Architect's Response Letter

Project: Event Center
Date Issued: May 6, 2024
Issued by: Daniel Duran
Modulus Architects

To: COA Development Review Services

PROJECT TITLE	EVENT CENTER SHELL	PROJECT NO.	JOB NO.	DRAWN BY:	SHEET
	AIRTECH CT SE ALBUQUERQUE NM, 87106				
PROJECT MANAGER		PROJECT MANAGER	PROJECT MANAGER	PROJECT MANAGER	PROJECT MANAGER
SHEET TITLE	ARCHITECTURAL SITE PLAN

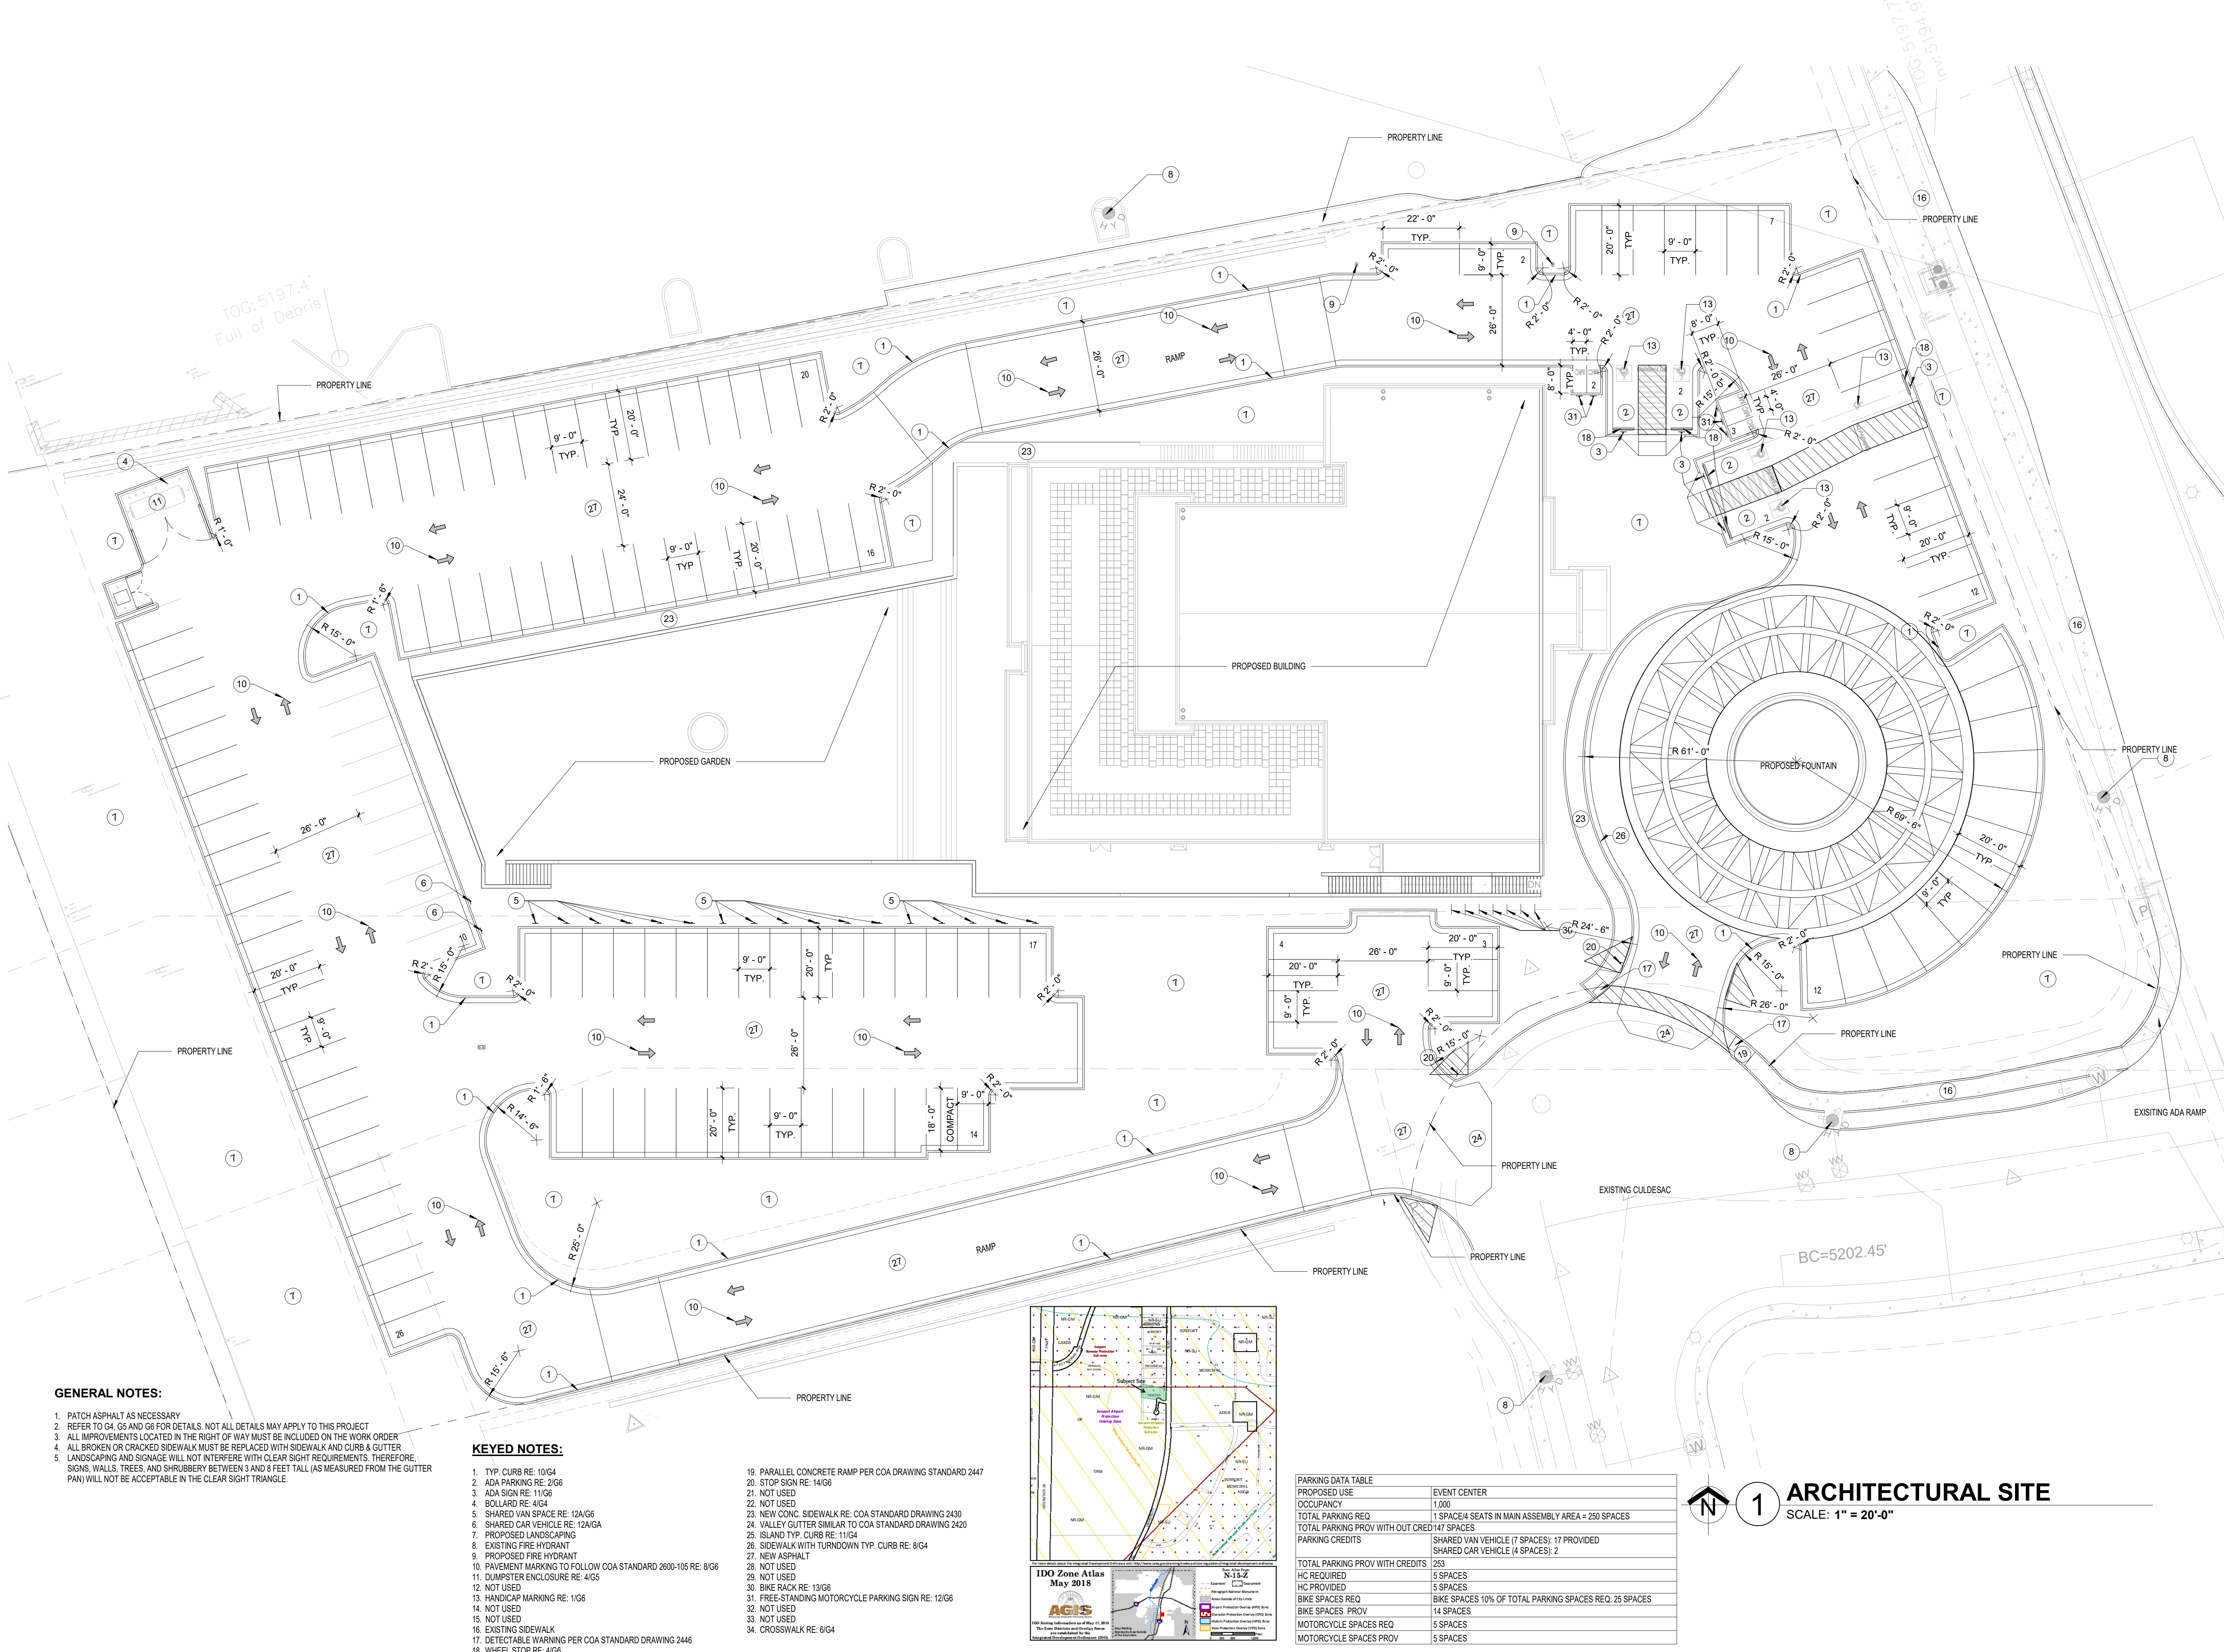
1. There should be 8 accessible parking spaces when the total number of parking spaces provided is 101-300 (2015 NM Accessible Parking Checklist). In addition, 2 van spaces should be provided. Revise the parking table as necessary, add three more accessible parking spaces and show which 2 accessible spaces will be designated as the Van Accessible spaces. **As per the 2015 NM Accessible Parking Check list, we have updated our plan to have 8 accessible parking stalls and updated two spaces to accessible van spaces.**

2. Where are the Shared Car Vehicle spaces? **Shared car parking are keyed note 6**
3. The two "Compact" spaces should have "COMPACT" pavement markings in the rear of the space. **Compact spaces have been updated to have COMPACT markings.**

4. Show the drainage inlet on the plan that is located in the west/northwest area of the cul-de-sac. The gutter transition begins 5' on either side of the inlet. It appears you may have to relocate the inlet, if approved by Hydrology. This will require a drainage submittal to Hydrology and a Work Order for the relocation. It may also require reconstructing the cul-de-sac to change the low point to the new inlet location. **As per our site updates, the inlet is now out of the west entrance of the culdesac.**

5. There is a patterned surface around the fountain, which appears to be where vehicles will drive. Provide: material, width of driving surface and inside radius. **The Material of**

6. The patterned surface in comment #2 above, overlaps the curb and gutter in a few places. Probably should reduce the diameter of the patterned surface. **The material for the pattern will be Colored Concrete.**

7. Is there a curb or similar (e.g. apron) to prevent drivers from crashing into the fountain? **Yes there is a concrete curb.**
8. Provide the width of the drop-off lane on the west side of the patterned surface. **Drop off lane width is 10'-0" it is provided on the site plan**

9. Please label the front door/main entrance. **Main Entrance label is provided.**
10. Provide/show the 6' accessible path from a ROW to the building. **6' accessible ROW provided on the east side of the site.**

11. The sidewalk and landscape area appear to merge at the building entrance and there is no accessible path from the accessible spaces to the front door. **The sidewalk and landscape area do not merge at the front door. The pedestrian path goes around it to go into the main entrance.**

12. What are the slopes of the "ramps" on the north and south sides of the building. Max is 5%. I noticed the site drops approx. 30 ft from the cul-de-sac to near the west property line. **Slopes of the drivable ramps are noted on the site plan. The calculations were done by the civil engineer.**

13. Do the perpendicular lines cross the ramps at the east and west end indicate change in slope? It would help with visibility if the south ramp flattened 50 ft or so from the flowline in the cul-de-sac. **Yes the perpendicular lines indicate the change in slope.**

14. It appears you have the 5' minimum keyway distance in the small parking lot south of the building. Please add a dimension. **Dimensions have been added to the keyway.**

15. The mini clear sight triangles are drawn too far from the back of sidewalk at the east entrance. **Clear sight Triangles have been addressed for both entrances.**

16. Show the existing sidewalk, Keyed Note 16, between the proposed entrances. **Existing side walk between entrances has been noted with Keyed note 16**

17. Provide dimensions for the spacing between the bike racks as well as the distance from the building. A bicycle parking space is 2'x6' (4' between racks) with a 1' clear zone around the perimeter of the bike racks. A detail may be helpful. **Bike rack dimensions have been added.**

18. The proposed western entrance will need ramps on either side of it and please draw the proposed valley gutter. **Ramps have been provided at either side of the western entrance.**
